# Agency Review Comments

Humphrey Platte Ave Self Storage

PPR2418

PR WATER MAIN - PROFILE VIEW
 HORZ SCALE 1" = 50'
 VERT SCALE 1" = 5'

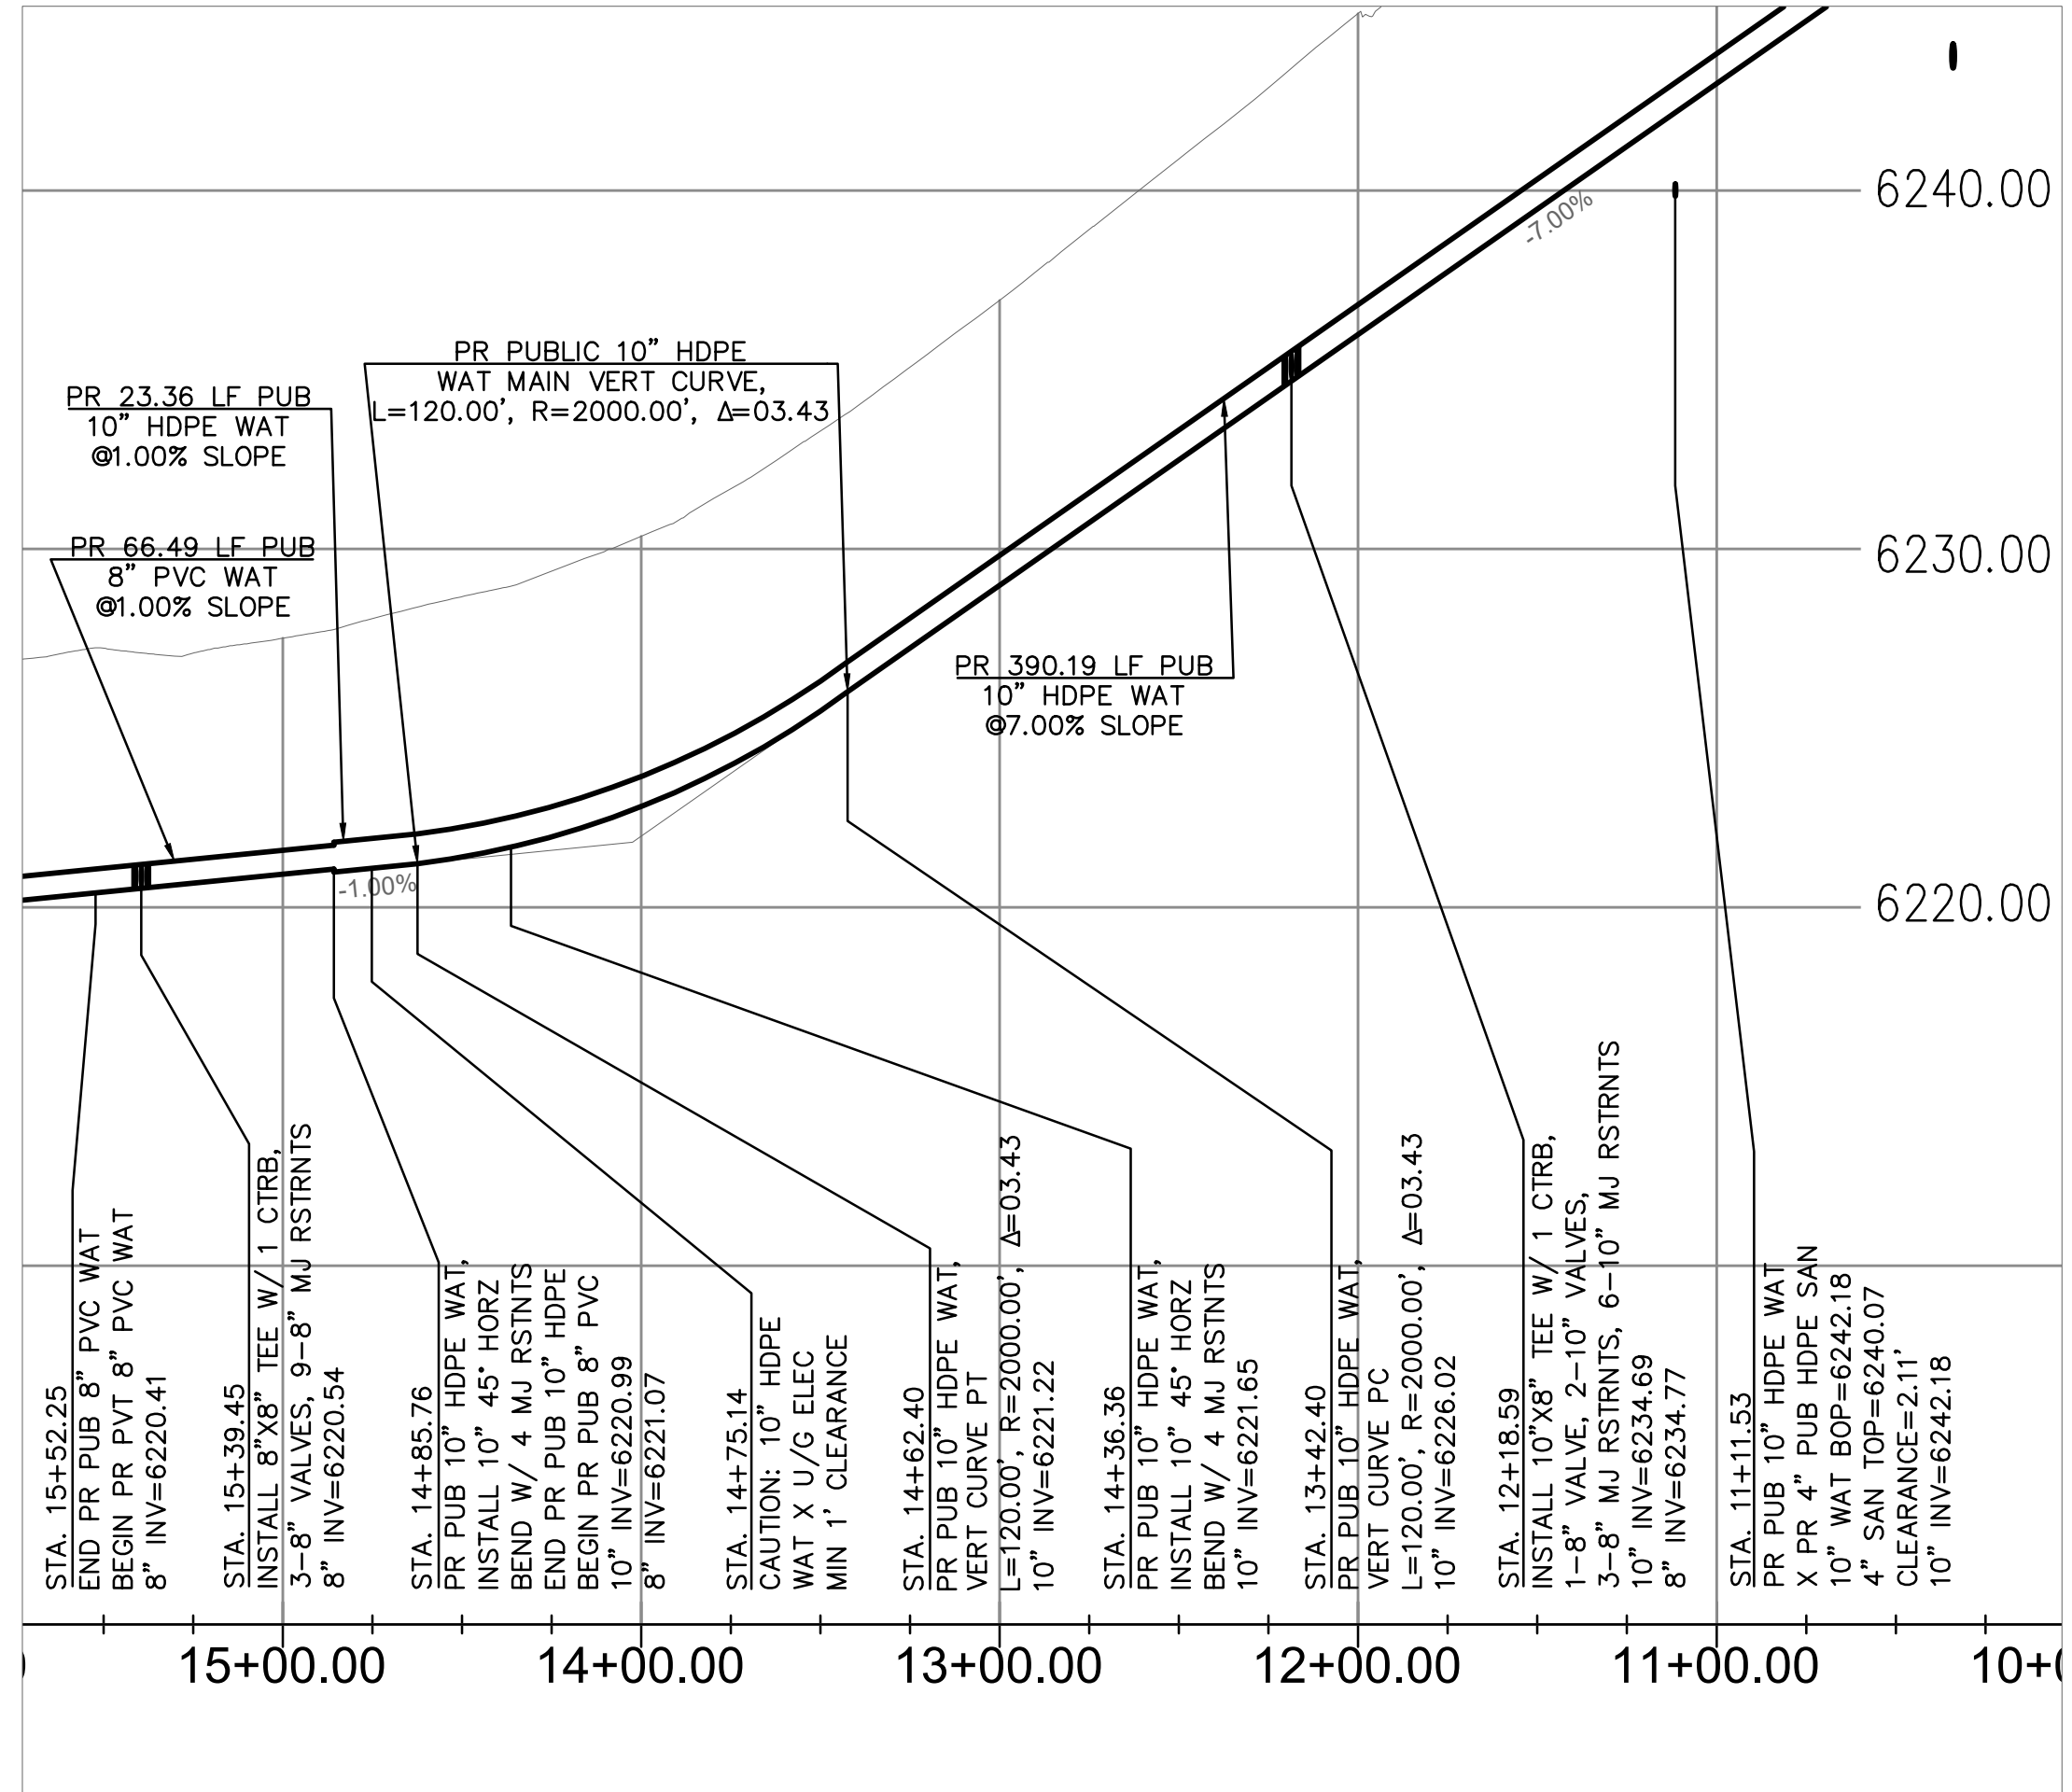
Cherokee Metro Dist		10/1/2024 3:16:56 PM
Cherokee Metro Dist	<p>All comments are in reference to the "Water &amp; Utility Service Plan"</p> <p>On page 1, cover page, under general notes and water plan notes it should state that methods and materials shall meet Cherokee Metropolitan District's standards. <b>Added.</b></p> <p>On page 2, it should state that manholes to Cherokee standard are a minimum of 5' Internal diameter. <b>Added.</b></p> <p>Additionally, on page 2, a sanitary tie in detail to the existing force main needs to be included within the utility plan (it can be on a sheet at end of utility plan). <b>There is no existing force main. The force main is proposed and nothing is tying into it.</b></p> <p>On page 3, include within the open area a utility crossing table with all proposed lines crossing existing; include both water and sanitary lines for the crossing table and identify on plan. I have also attached marked up sheet of page 3 and page 5, "water plan overview" and "water main plan &amp; profile", from our District's locator. Add the Blue and Red marked notes to the respective sheets. <b>Crossing table added.</b></p> <p>Additionally, throughout the "water &amp; utility service plan", starting on page 2 and going to page 7. All HDPE pipe that is on public road needs to be changed to PVC (this is because Cherokee Metro does not have the equipment to do HDPE line fixes). Lines that are in Private roads can stay as is. <b>Pipe has been changed from HDPE to PVC.</b></p>	10/1/2024 3:14:02 PM
